FROM: Emma Waters (Mrs)

SUBJECT: EG/57/16/PL

DESCRIPTION: Medical centre with pharmacy retail unit & other ancillary uses together with access onto Barnham Road & associated car parking. This application is a Departure from the Development Plan.

SITE: Land adjacent to the Croft Practice, Barnham Road, Eastergate, PO20 3RP

SITE PLAN SCALE 1:200

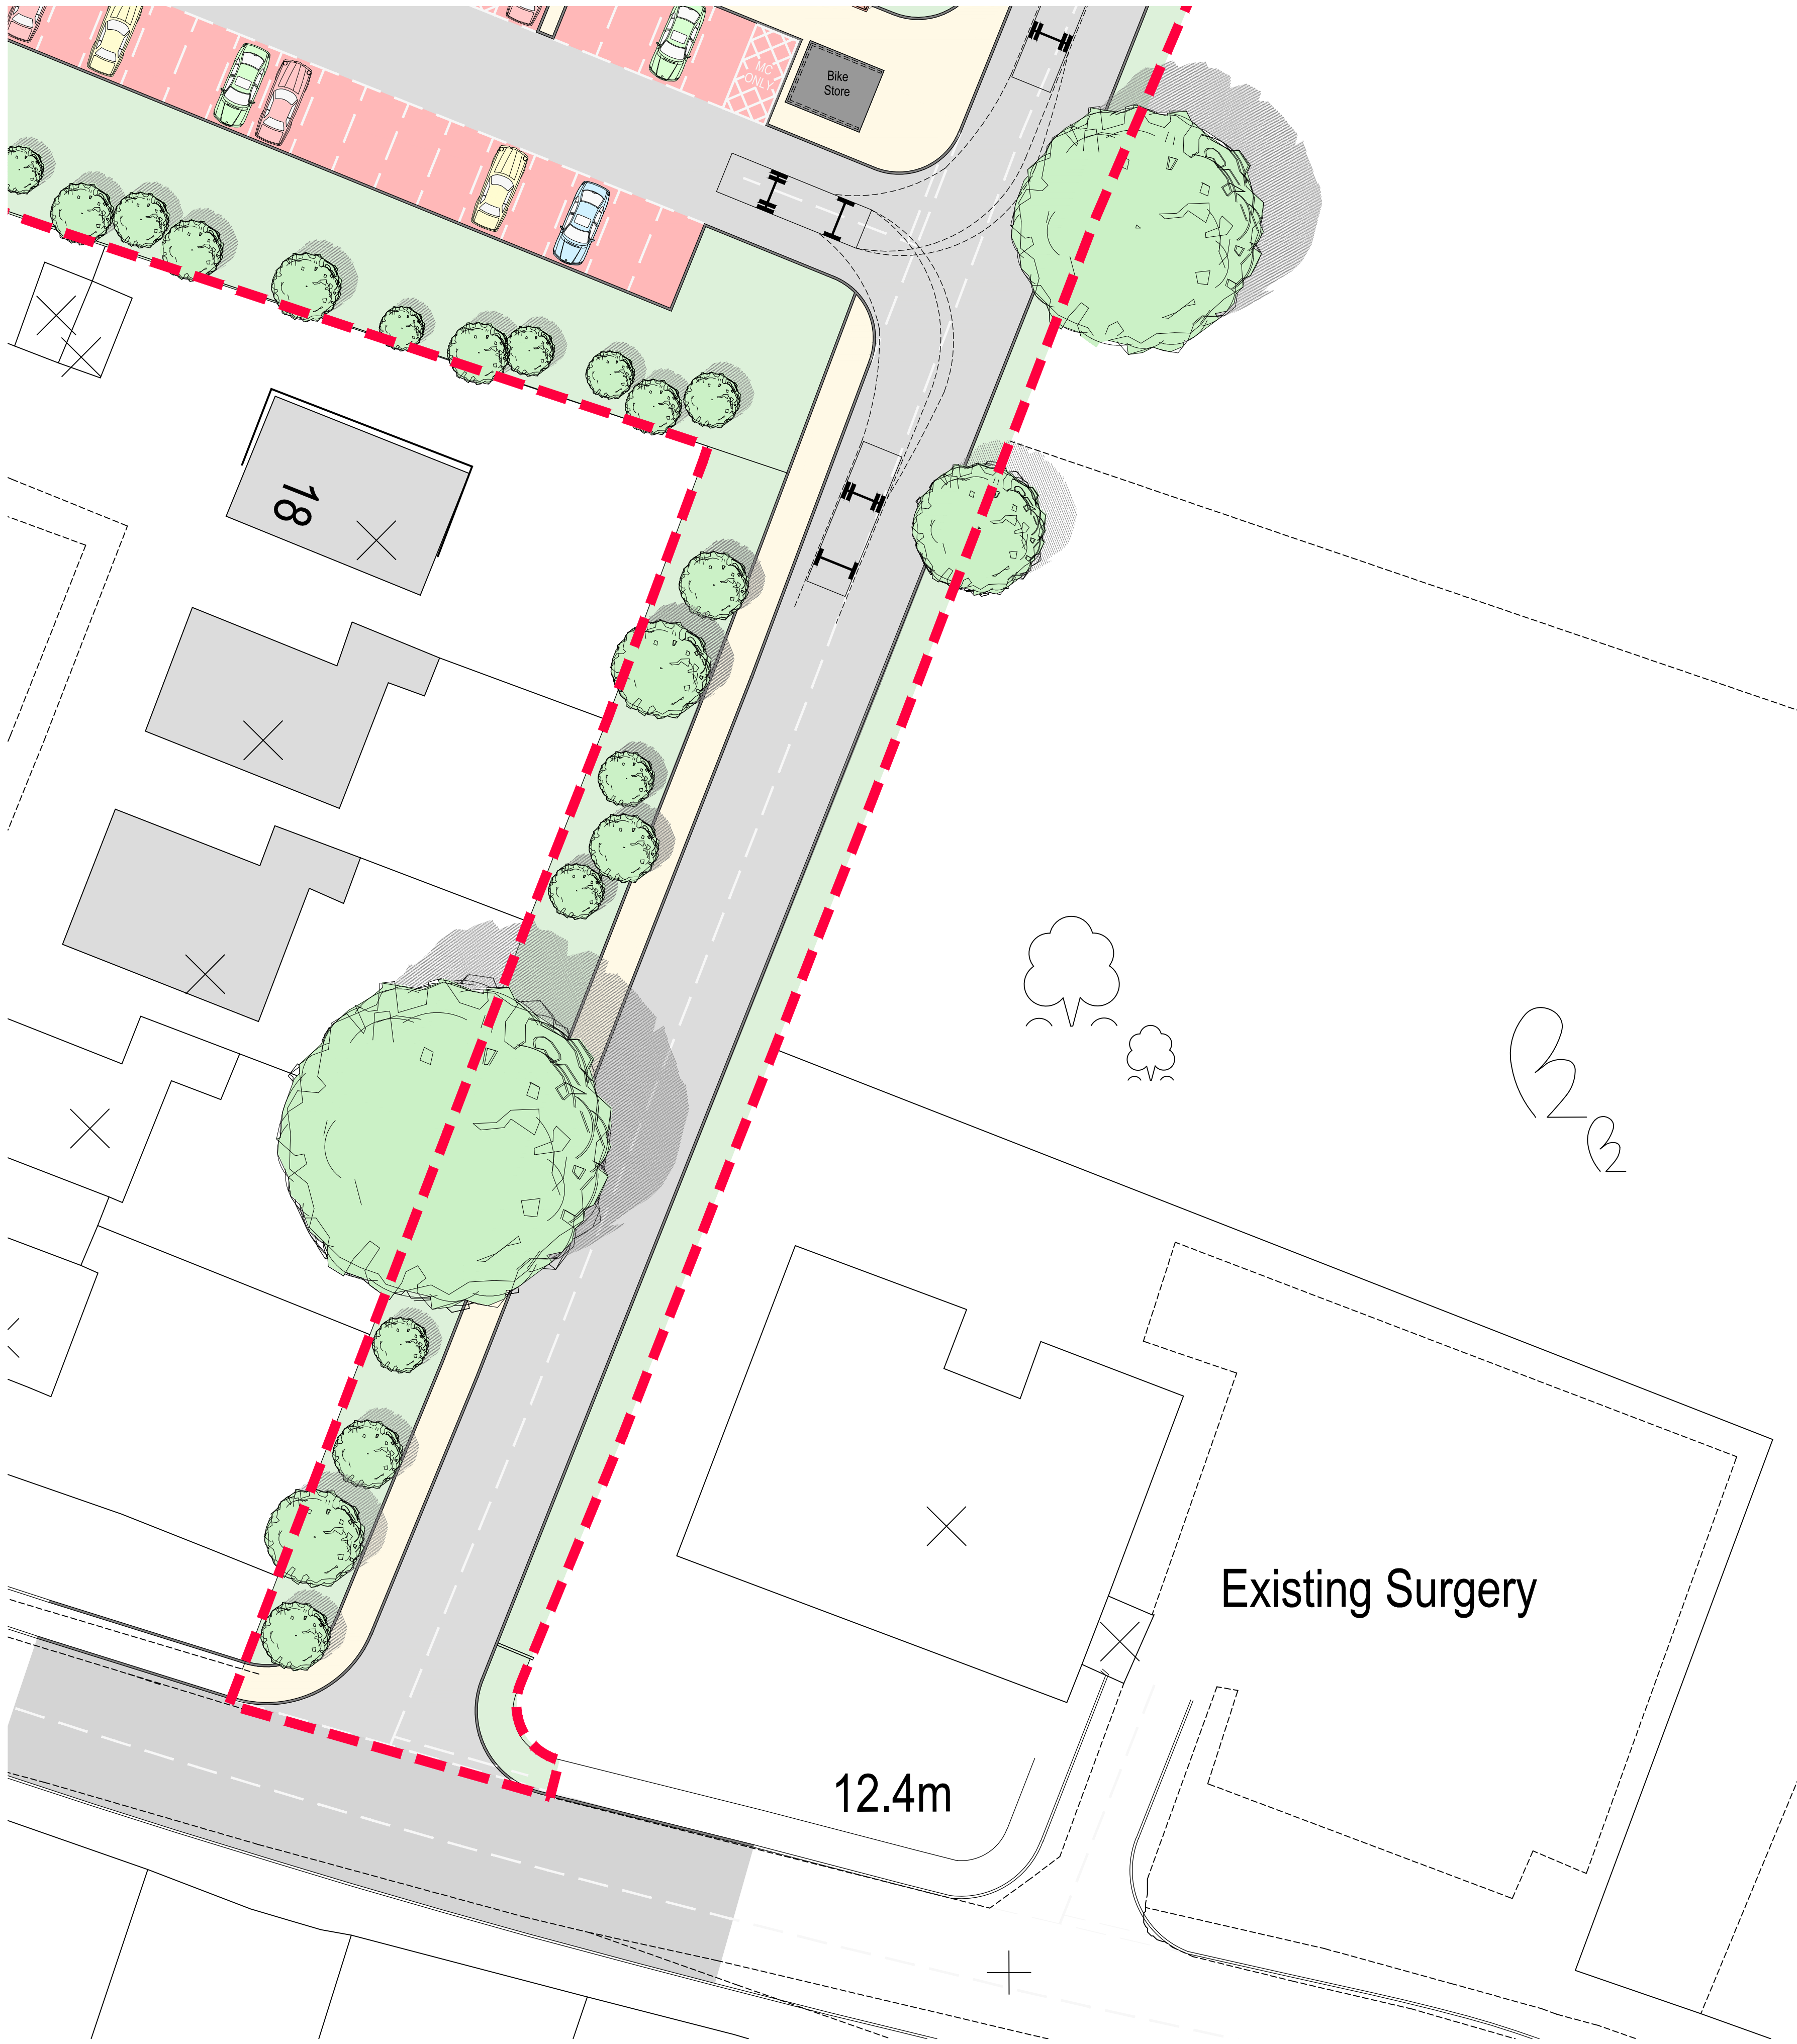
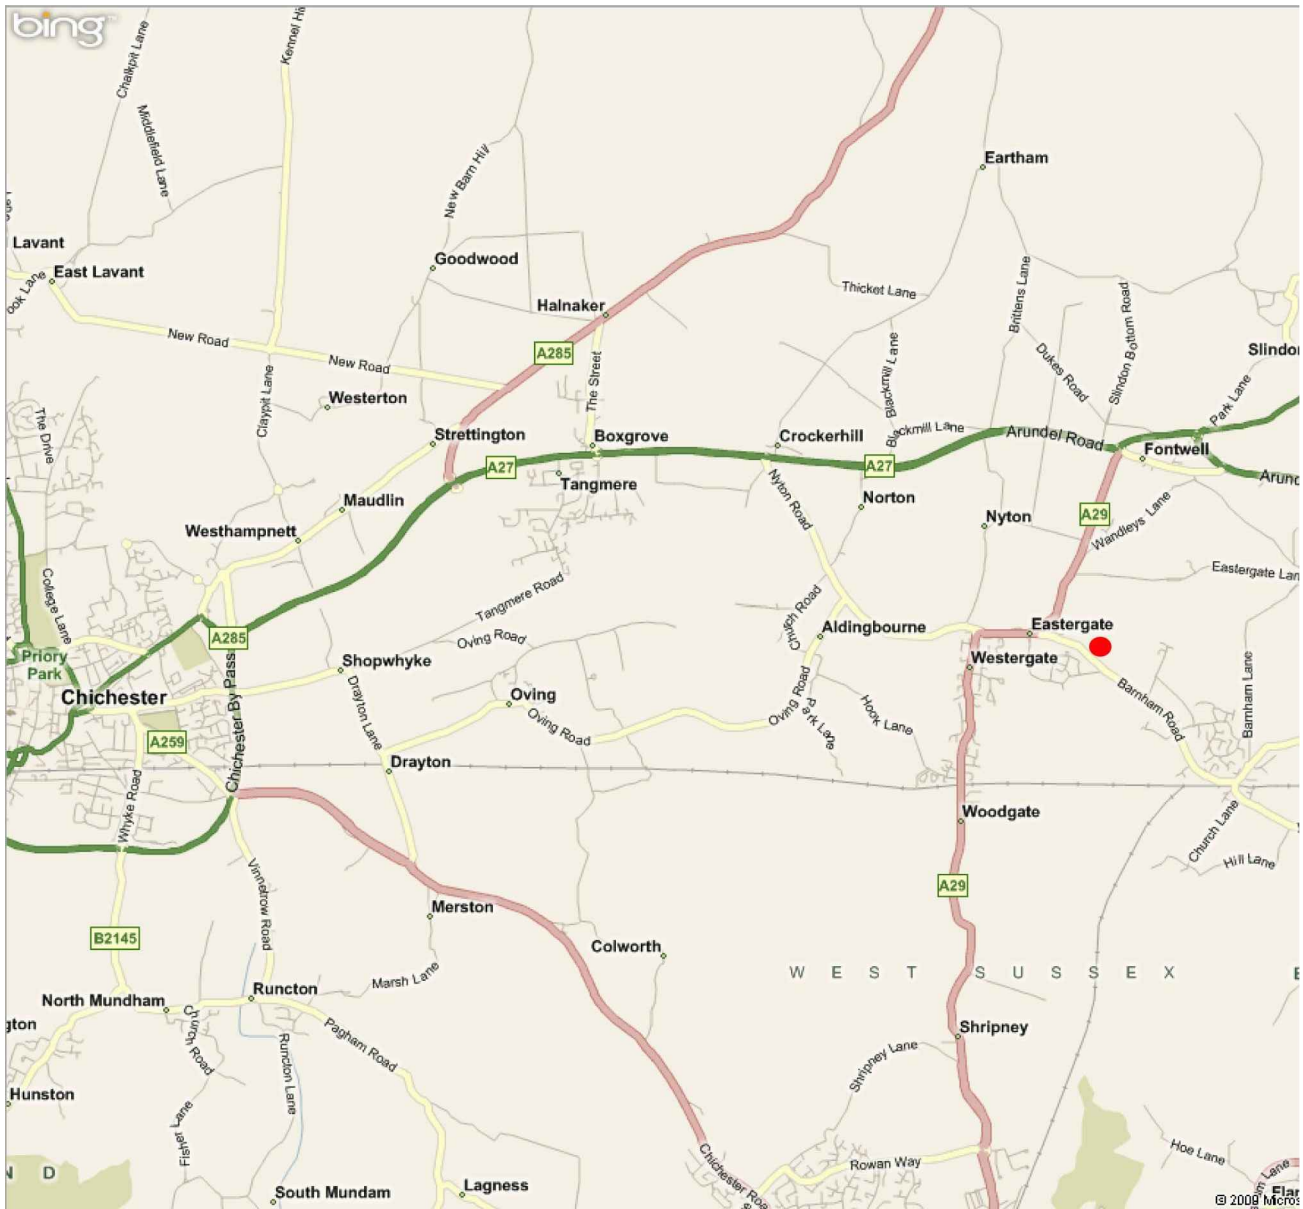
The proposed site has an existing vehicular access/crossover that presently serves a staff car parking area. This access is to be upgraded to a bellmouth with appropriate kerb radii. No plan has been provided to demonstrate how the access will work or how

it relates to the overall site access arrangements. A scaled plan detailing the access works needs to be submitted to be assessed. Visibility splays of 43m in each direction from a 2.4m setback should also be demonstrated.

It is noted that section 5.07 of the Design & Access Statement indicates that the 28 parking spaces to the south of the building will be for visitors to the surgery, whilst the 26 spaces (including 7 disabled spaces) to the north of the building will be mostly for staff. This will also serve as overspill for the front car park should the practice experience higher than anticipated levels of visitors. Given that the existing surgery provides 28 spaces for patients and a separate staff car park with 15 spaces, the LHA are concerned that the combined number of parking space for visitors and staff as proposed will be insufficient given the increase in size of the building and consulting rooms. There would be more people visiting the site and more staff to operate the surgery. The LHA would advise that given the known access and parking issues of the current surgery the applicant submits a revised parking strategy, taking on board the standards referred to under the WSCC Parking Standards.

A dedicated turning head has been shown at the end of the access road. This appears small and there doesn't appear to be any barriers to stop parking occurring on the site access road in this location to make sure this area is kept clear for large vehicles to turn at all times.

It is also not clear what type of vehicle has been used on the tracking diagrams. The LHA would request that revised tracking is provided to demonstrate that a large refuse truck could turn on site to exit onto the highway in forward gear.

Tracking should also be provided to demonstrate that the proposed access off Barnham Road could accommodate two passing vehicles and a refuse truck entering and exiting the site safely.
